**SUBJECT**  
City Gates Phase 2 - Interim Parking Design  
Arcadis Engineering Review

**TO**  
Andrew Kent  
Senior Director, Developments  
Killam REIT  
Halifax, NS

**DATE**  
22/08/2025

**PROJECT NUMBER**  
38729-5.2.2.1

**PHASE 2
INTERIM PARKING**

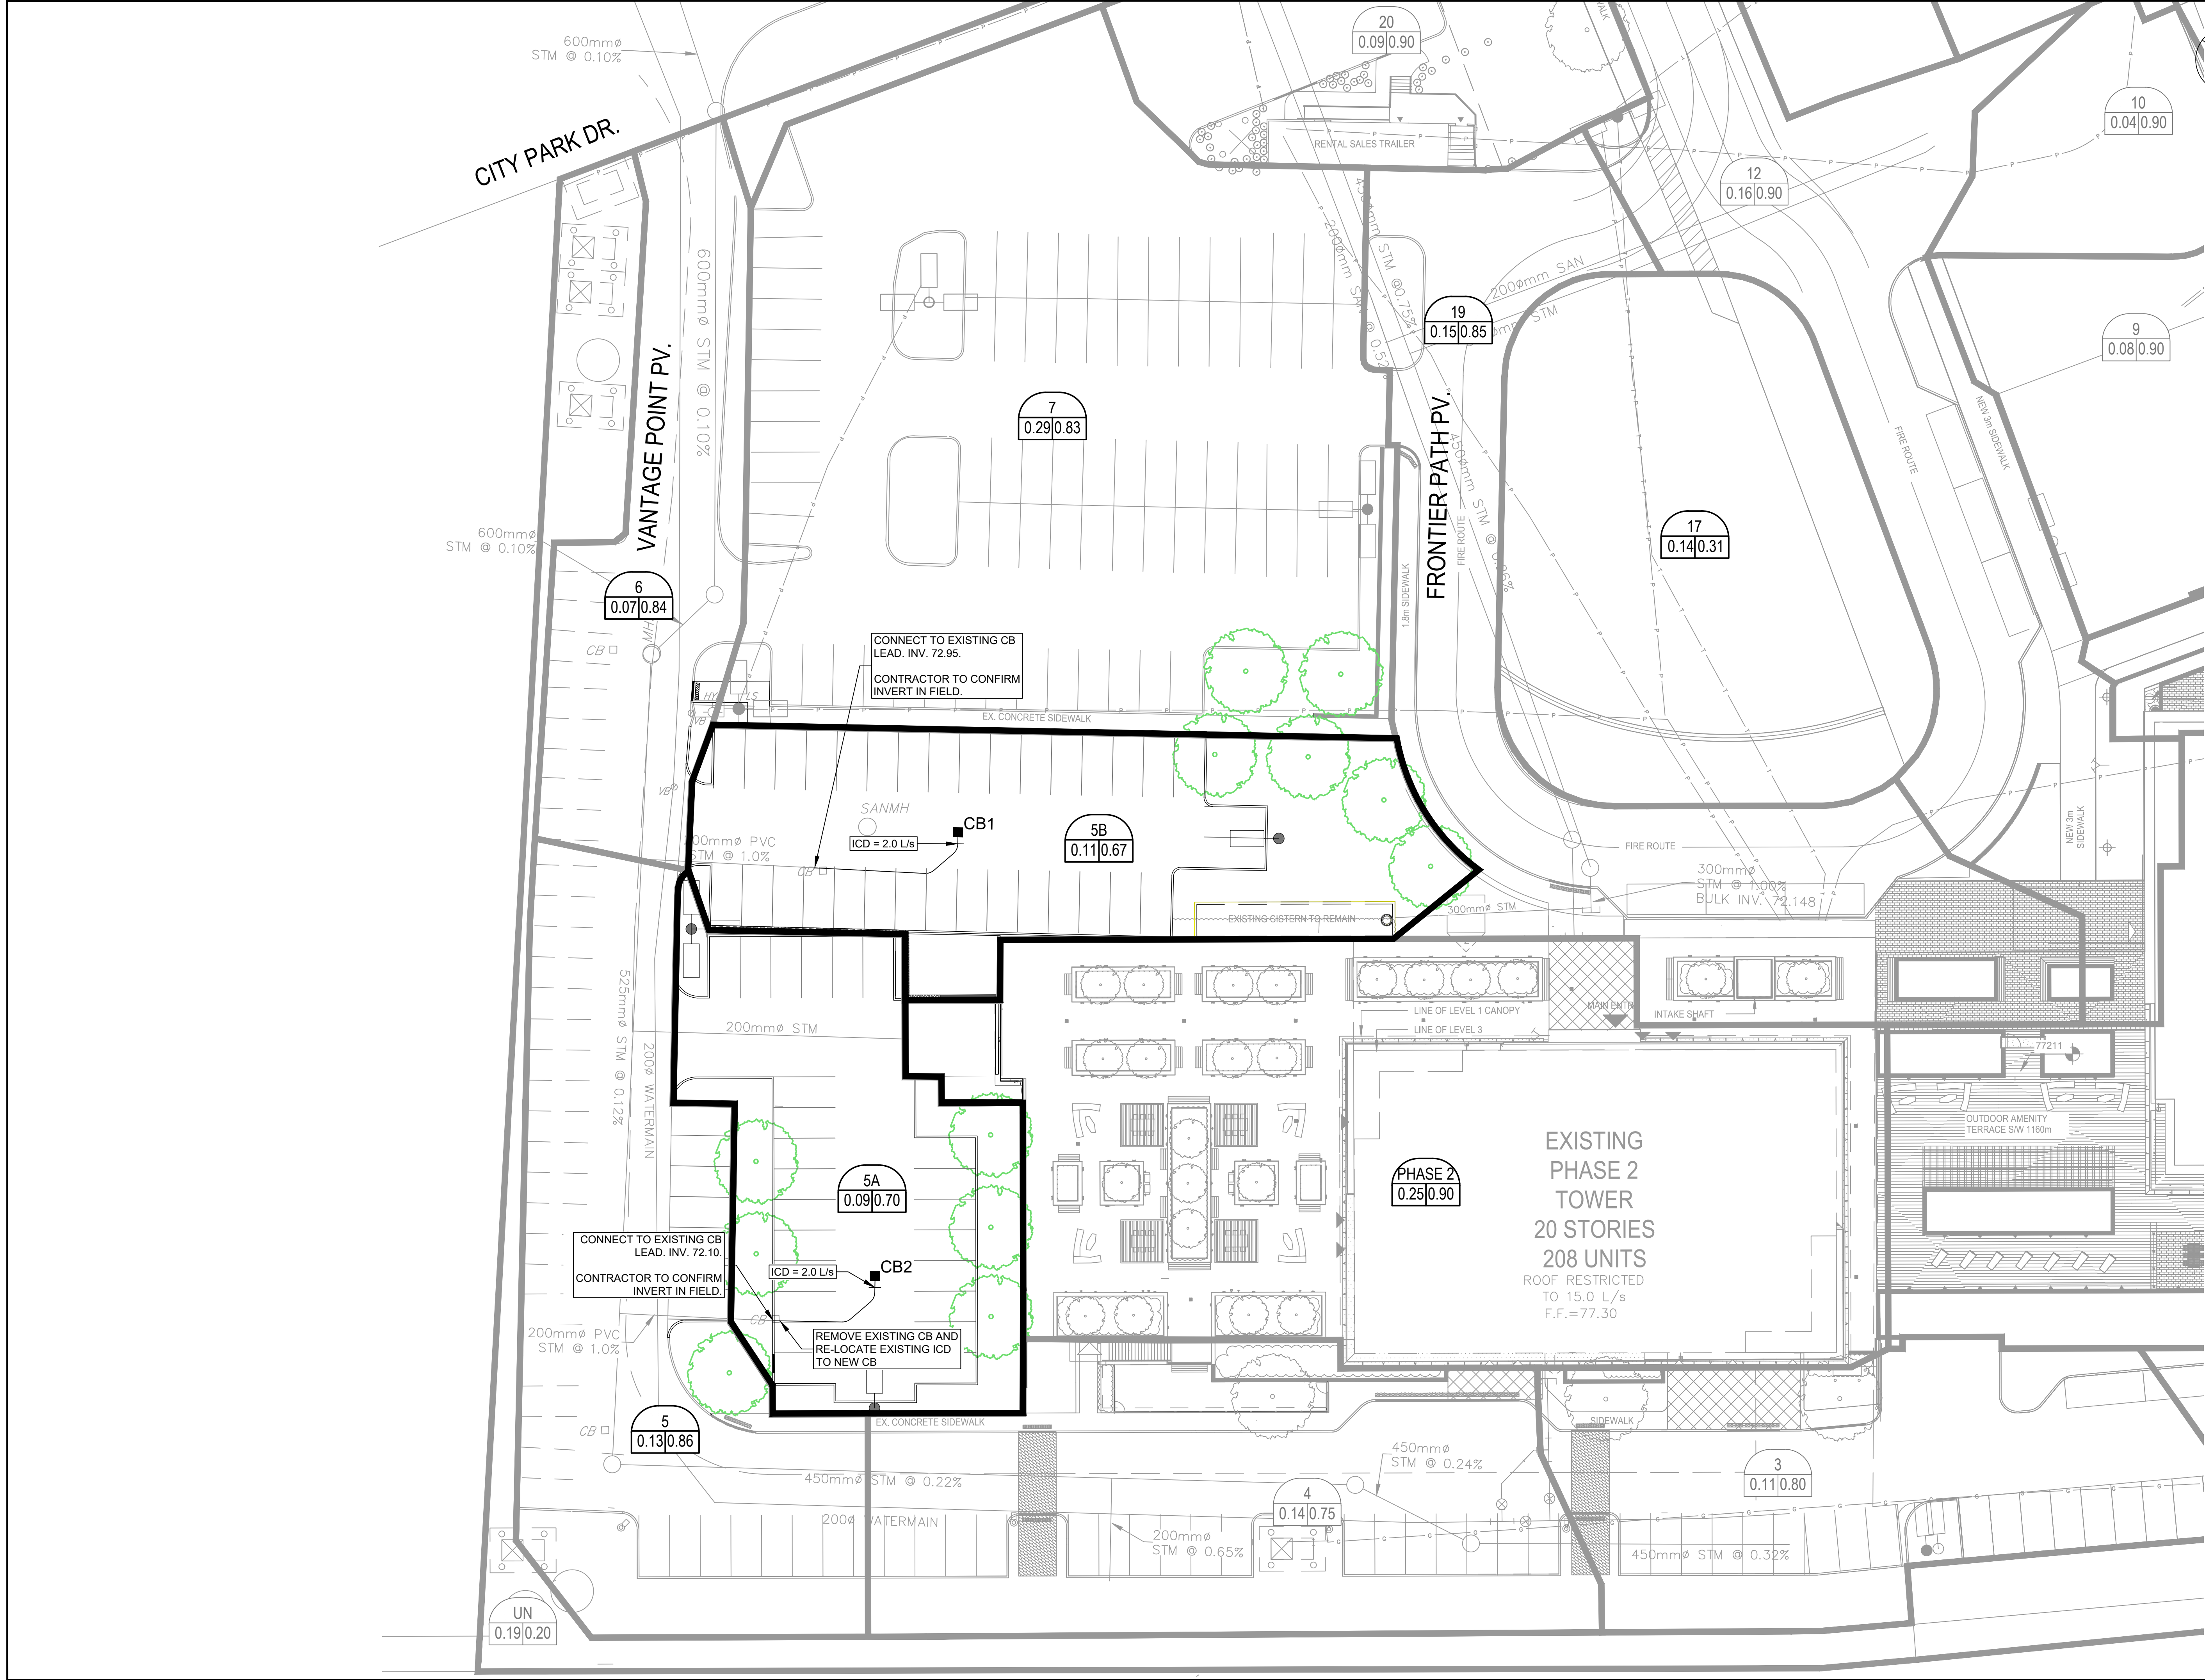
Clarify where offsite this drainage area overflows to. Is it to private property or the ROW?

There will be no overflow as all 5yr and 100yr volumes will be captured within the designed systems. Wording on the updated calculation sheet has been adjusted to reflect this.
